**Harnett County**  
420 McKinney Pkwy  
LILLINGTON, NC 27546  
Phone:  
Fax:

**SUBJECT: BRES2210-0026**  
**BUILDING RESIDENTIAL**

Here are the results of all Inspections located at **1200 OLIVE BRANCH RD:**

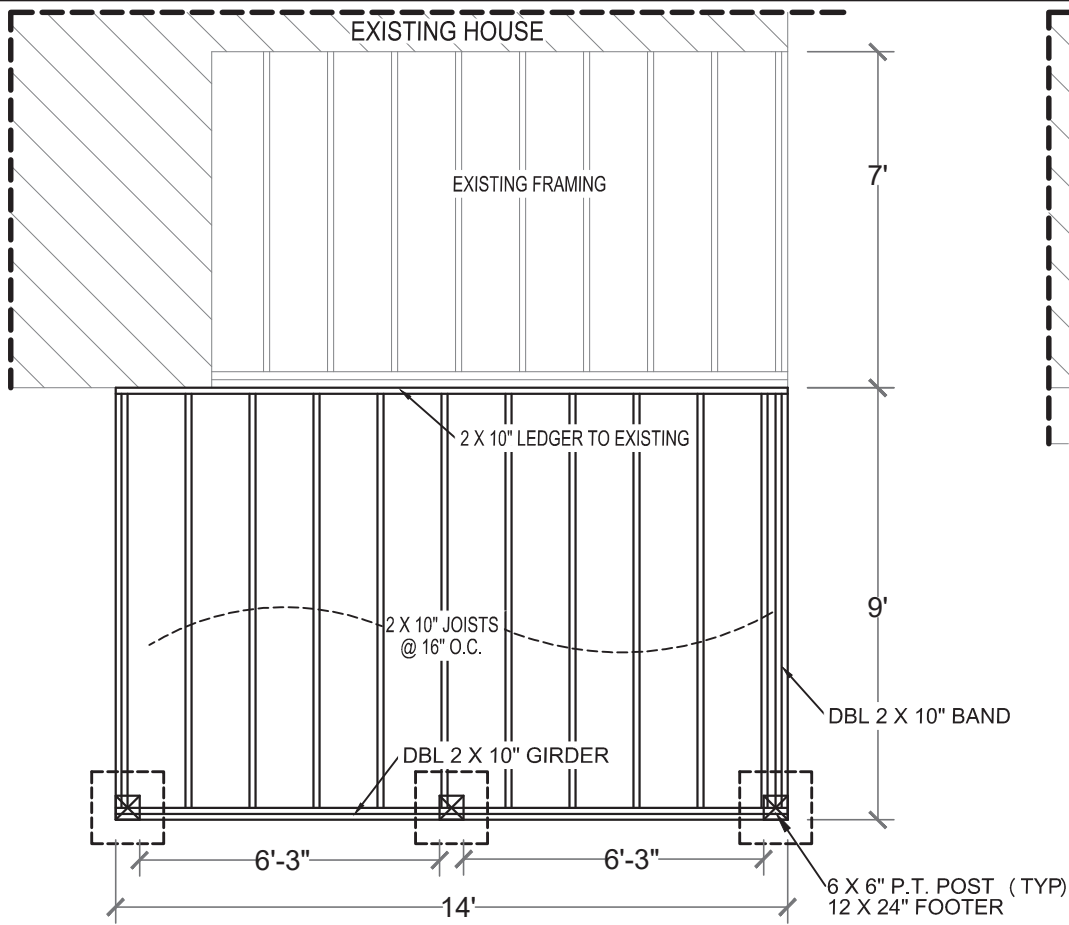
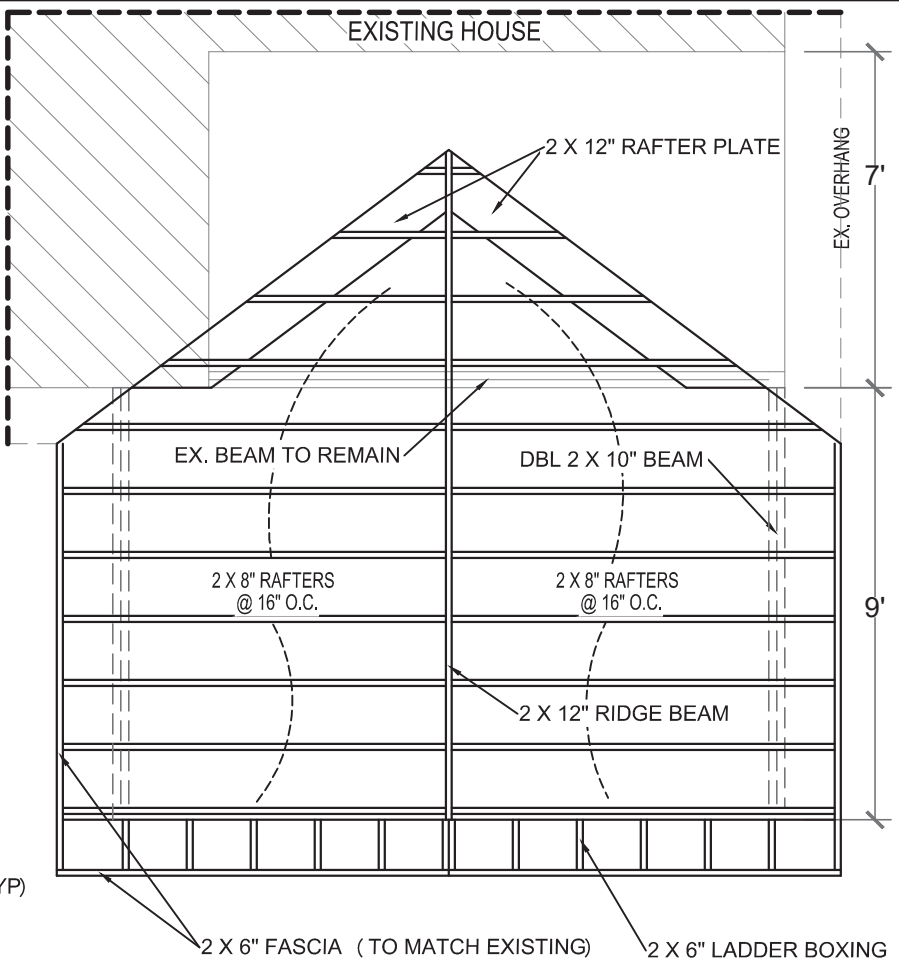
1. Rail guard posts at steps must be attached with minimum of 2- 3/8" galvanized bolts. 2. The floor joists at top of steps needs either hangers or ledger strip. 3. Need letter from the engineer on the plans for stick built roof. Plans only show posts supporting light panelized type roofing.

Roof system will need to be engineered for sunroom. The plan that was stamp by engineer and approved by central permitting has a different design than plan the field. If no ceiling joists or rafter ties are in the lower third of rafters then the ridge formed by the rafters has to be supported by a wall or girder designed in accordance with accepted engineering practice.

Engineered roof and plans

JOB NO.  
 001591  
 SHEET NO.  
 DET.1

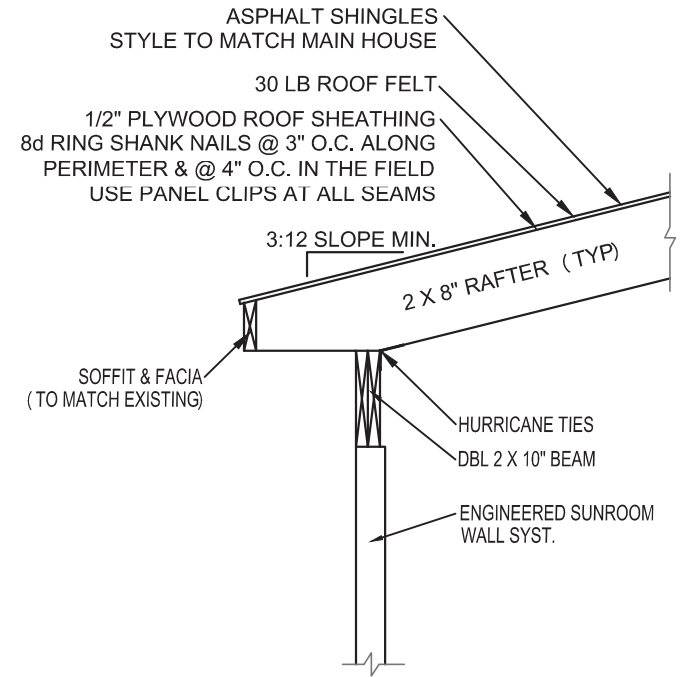
Need to bolt band. Can see at rough in. Track is good
